**To:** Charlotte Planning, Design & Development

**Date of Review:** September 27, 2021 **(Revised November 22, 2021)**

**Rezoning Petition #:** 21-118

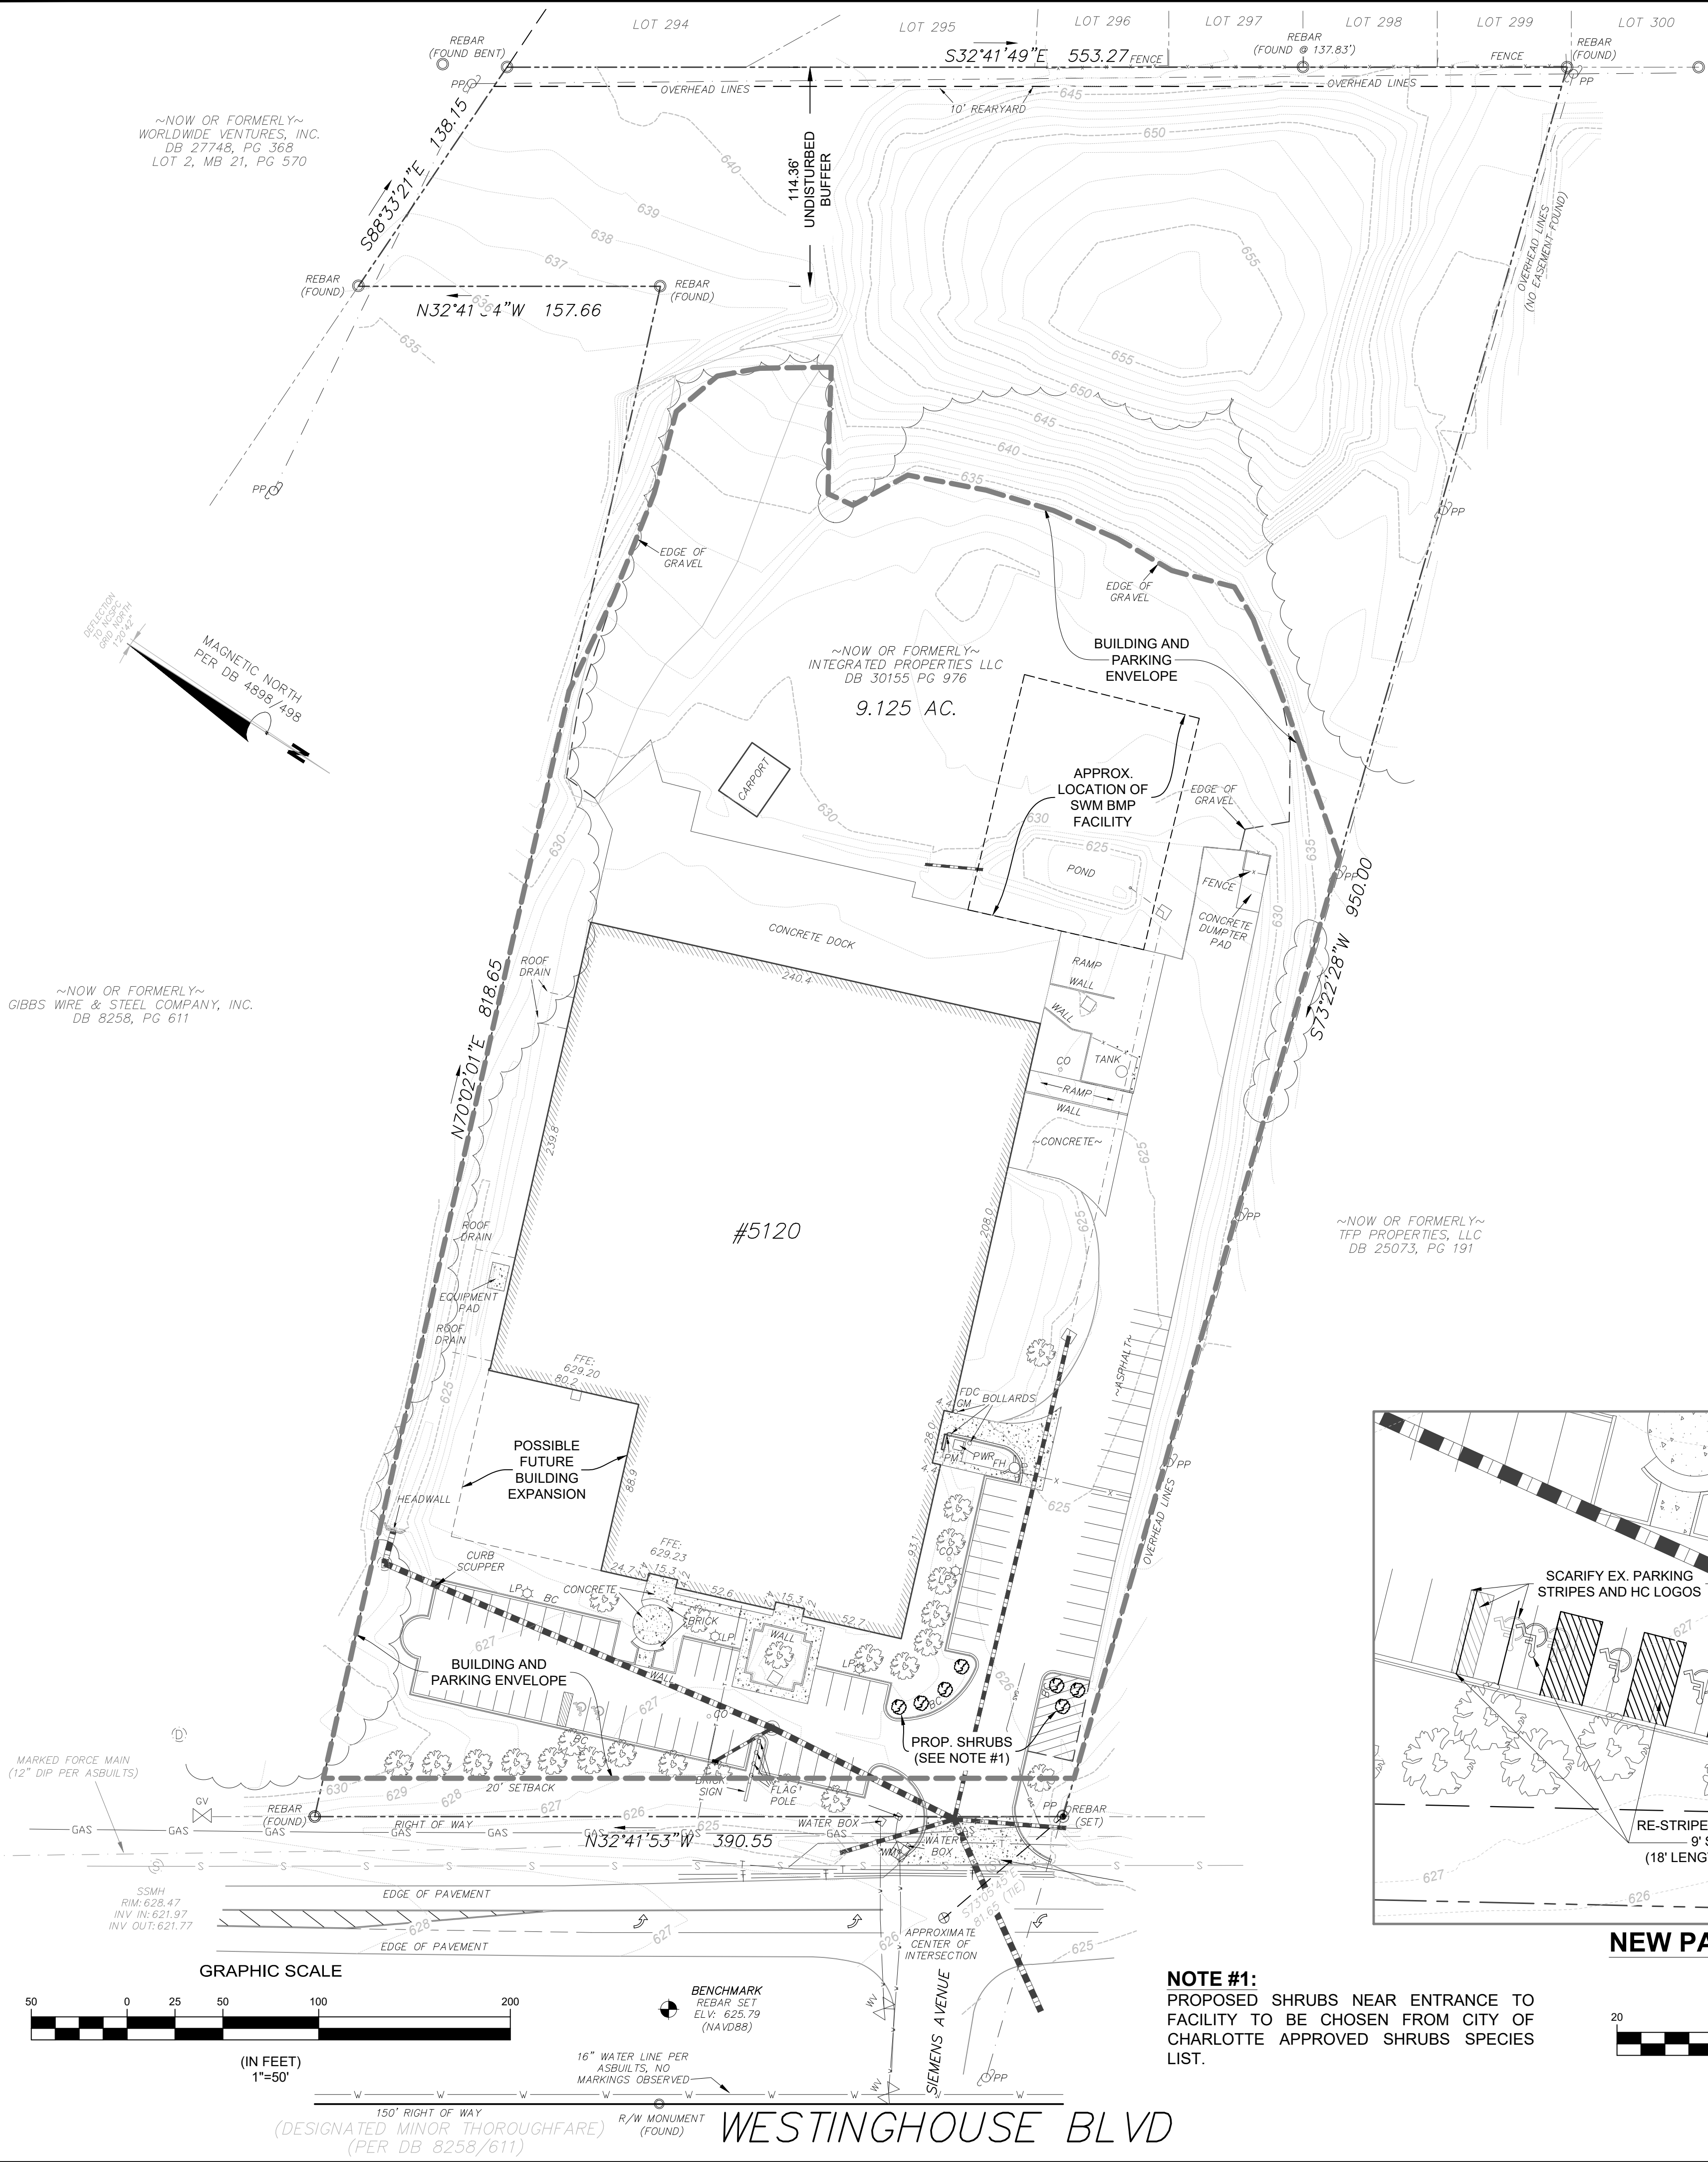
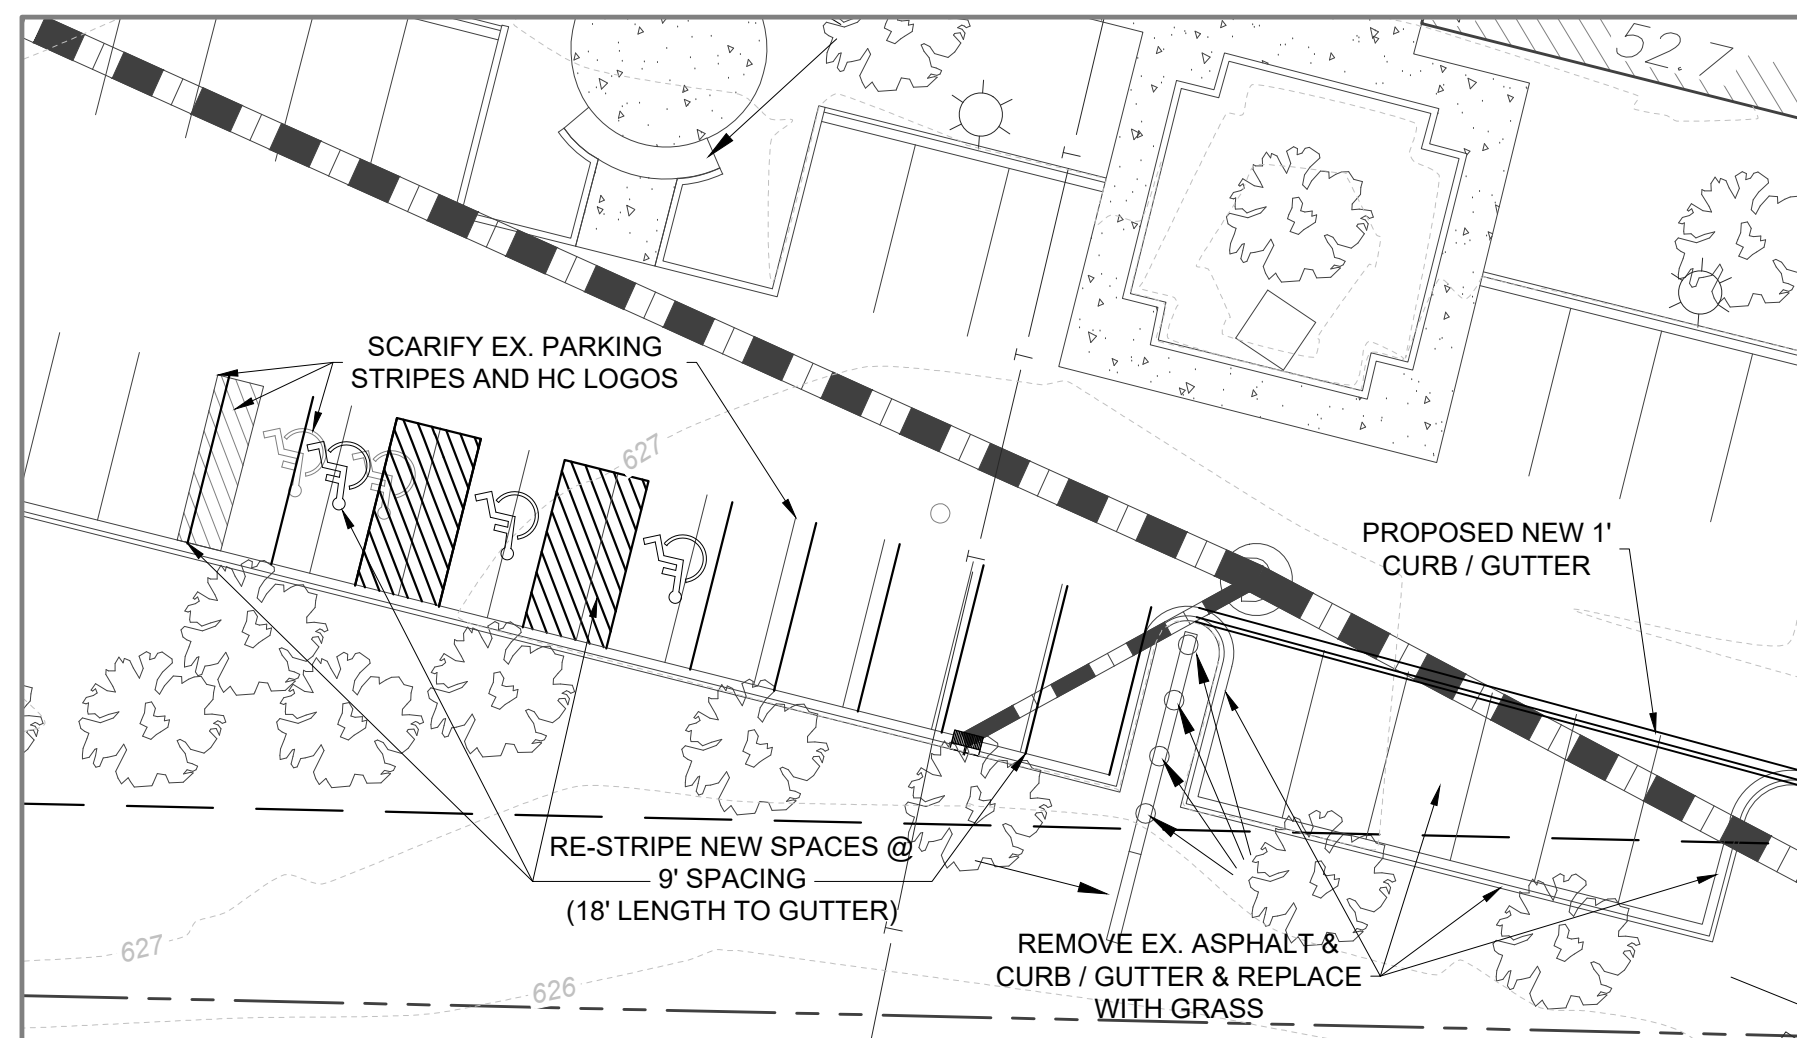
**This property drains to the Lake Wylie watershed basin, which is an impaired/degraded stream, and may contribute to downstream flooding. This project has the opportunity to mitigate future impacts to this stream, therefore, Storm Water recommends placing the following notes on the plan:**

(I) Storm Water Quality Treatment

For defined watersheds greater than 24% built-upon area (BUA), construct water quality stormwater control measures (SCMs) designed for the runoff generated from the first 1-inch of rainfall for all new and redeveloped BUA associated with the project. SCMs must be designed and constructed in accordance with the Charlotte-Mecklenburg BMP Design Manual.

(II) Volume and Peak Control

For defined watersheds greater than 24% built-upon area, control the entire volume for the 1-year, 24-hour storm for all new and redeveloped BUA associated with the project. Runoff volume drawdown time shall be in accordance with the Charlotte-Mecklenburg BMP Design Manual.

For commercial projects with greater than 24% BUA, control the peak to not exceed the predevelopment runoff rates for the 10-yr, 6-hr storm and perform a downstream flood analysis to determine whether additional peak control is needed and if so, for what level of storm frequency, or if a downstream analysis is not performed, control the peak for the 10-yr and 25-yr, 6-hour storms.

For residential projects with greater than 24% BUA, control the peak to not exceed the predevelopment runoff rates for the 10-year and 25-year, 6-hour storms or perform a downstream analysis to determine whether peak control is needed, and if so, for what level of storm frequency.
